Reference: Horwich Moor Farm,  
Horwich, BL6 6PR

### **RE: Proposed conversion of an agricultural building to a dwelling**

Proposed External & Party Wall / Ground Floor Detail  
 To achieve:  
 U-value 0.17W/m<sup>2</sup>K  
 Airborne Sound insulation - 45 DnT,w + Ctr dB

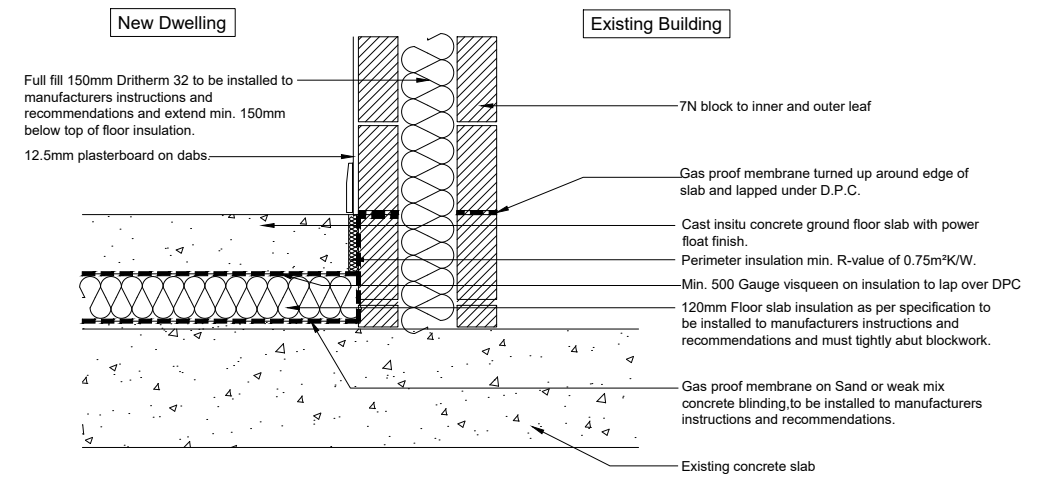
There is an adjoining agricultural building so the party wall should be constructed to meet the minimum performance standards stipulated in Approved Document E (this is mentioned within the specification) and, if there is access to the adjoining building, the party wall should be subject to sound testing upon completion under Regulation 41.
